Reference No:	2026/62/91382/W
Site Address:	56A, Hazel Grove, Cowlersley Lane, Linthwaite, Huddersfield, HD7 5TQ
Description:	Change of use of existing agricultural outbuilding to form part of residential accomodation at ground floor, new link extension to form new entrance area to link existing dwelling and outbuilding and creation of new amenity / external seating area within new new roof space of former agricultural building
Recommending Officer:	Joshua Merriman

DECISION – Conditional Full Permission

Officer Report – 2026/91382

Drawing Number  
 26\_801\_103

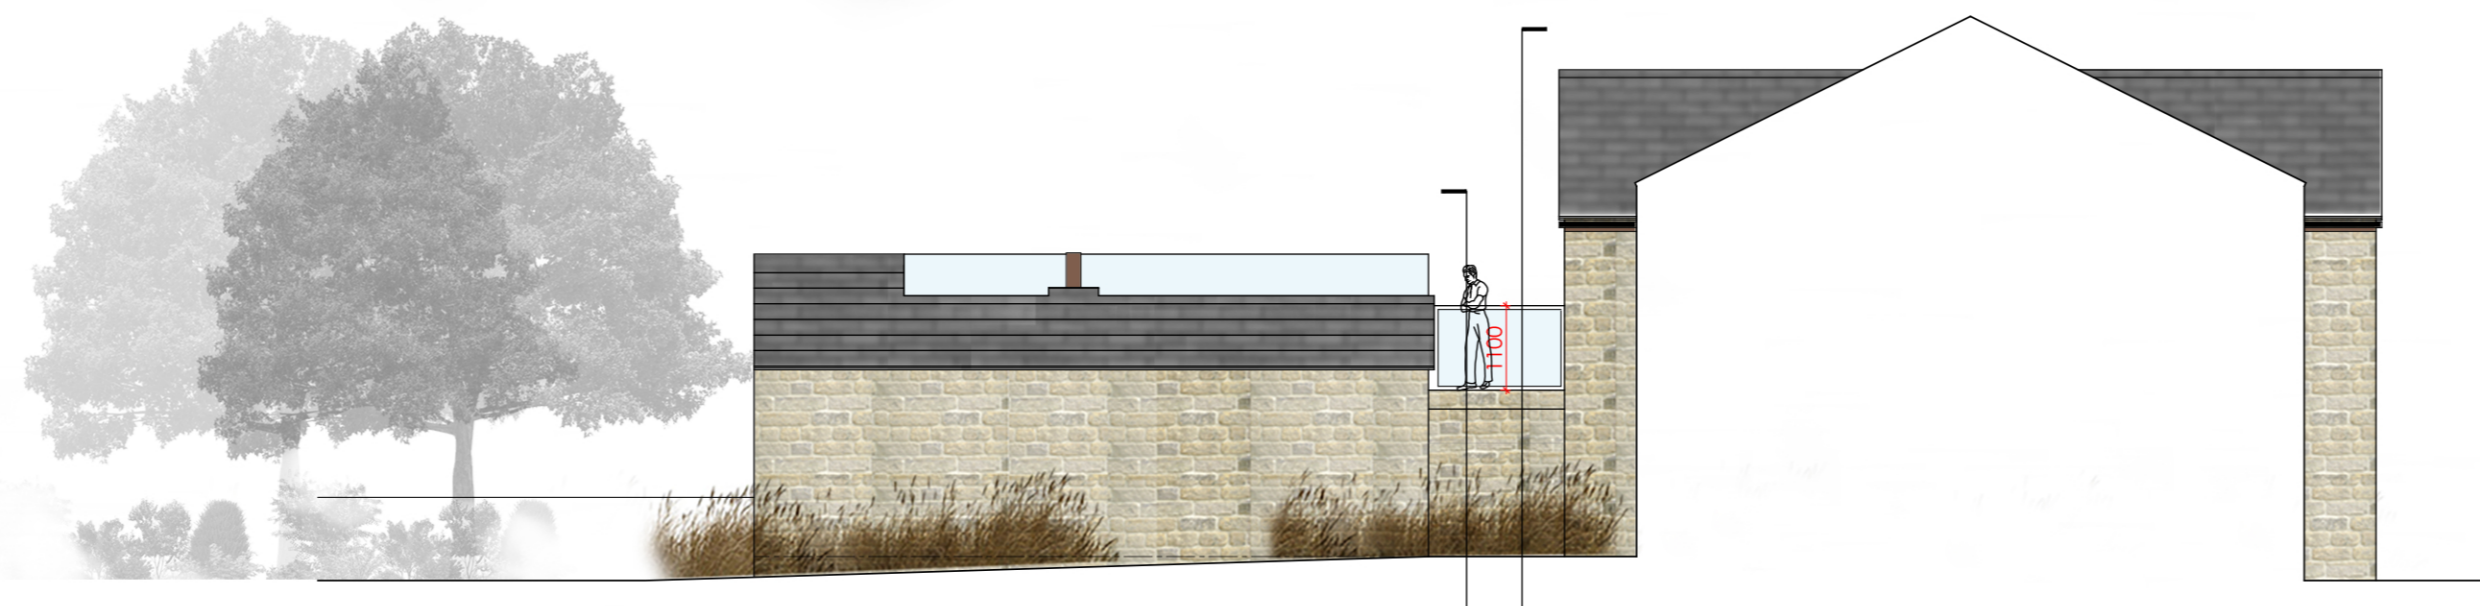
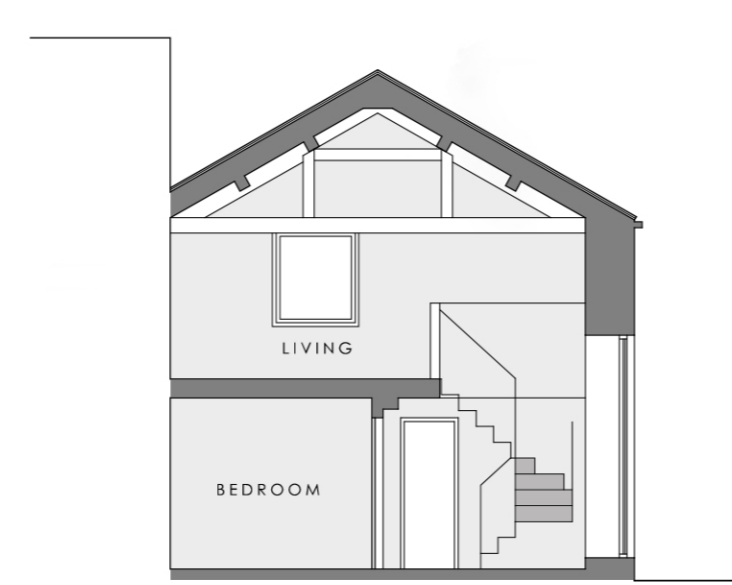
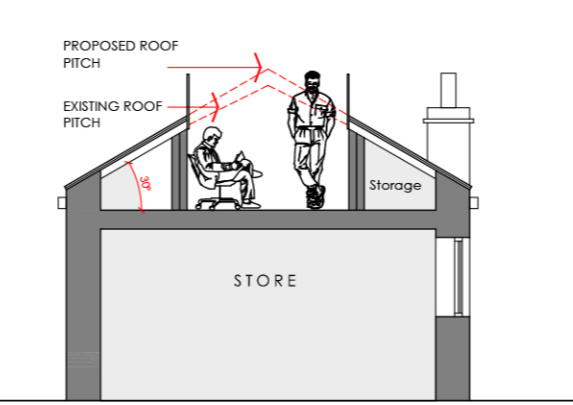
Revised plans were received to increase the height of the glass terrace screen and to ensure balustrades to the open terrace area were obscure glazed. The amended plans were considered acceptable by the case officer.

The proposed link extension and mezzanine floor to the converted outbuilding will have obscure glazed screens with the terrace above the link having a 1.8m tall screen that will mitigate the impact of overlooking as noted on the submitted revised elevation drawings. As such, there are no concerns to the overlooking impact to No. 56 Hazel Grove private residential amenity space or the first floor windows to No. 52 Hazel Grove.

3. The terrace shall not be brought into use until an obscurely glazed screen (to a minimum privacy level of Grade 4 or equivalent) to a height of 1.8m high has been constructed to the North East and South West facing elevations of the raised terrace. The obscure glazed screen shall thereafter be retained.
